11 March 2014

File No: 2013/087945
Our Ref: R/2012/13/B
Your Ref: SSD 4972 MOD 2

RE: Modifications to Four Points by Sheraton Hotel, 161 Sussex Street, Sydney

Drawing Title: **SLIP STREET EAST ELEVATION**
Drawing Number: **A-DA-0304**
REV: **H**
Scale: **1:200 @ A0**

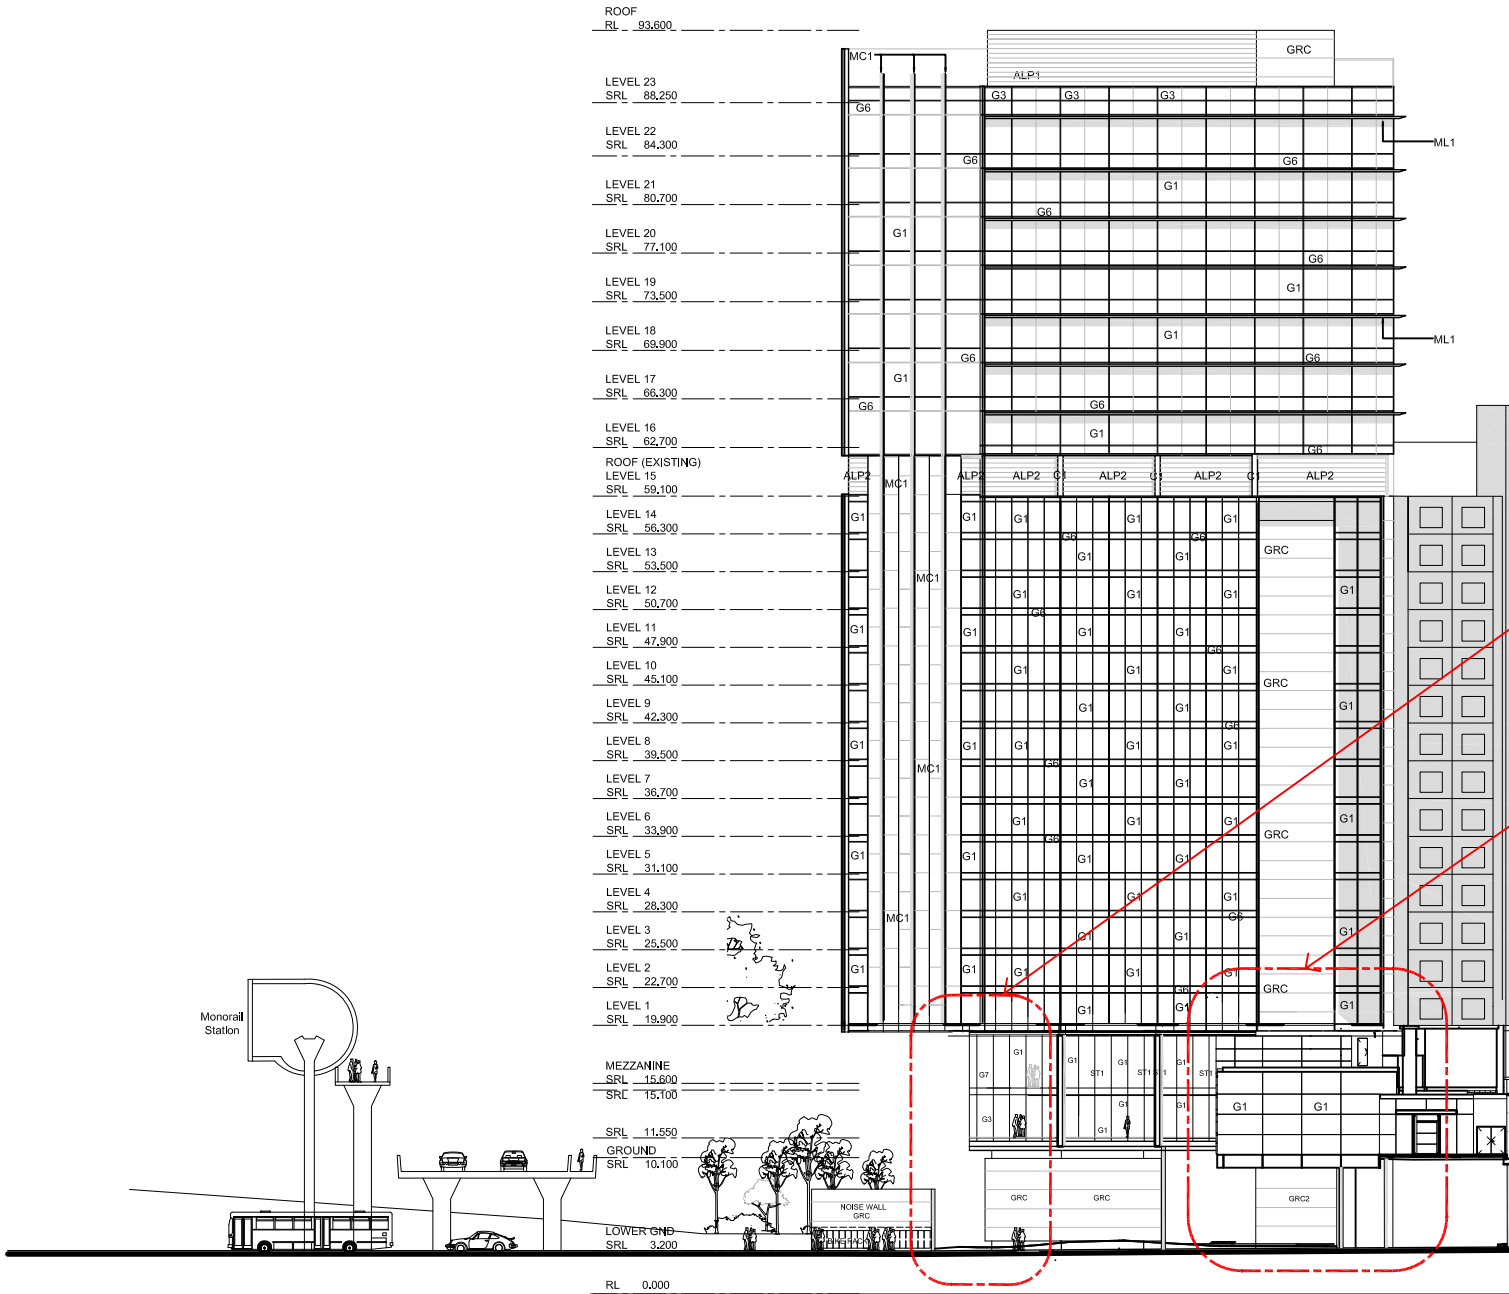
- The proposed external design modifications relate primarily to the western rear and southern side elevations, facing toward the Western Distributor and Pyrmont Bridge respectively, as well as supporting structures beneath the building form. Officers should ensure that the proposed modifications do not further obscure views of the heritage listed Corn Exchange and Dundee Arms buildings from Pyrmont Bridge, and that the setting of these buildings is retained.
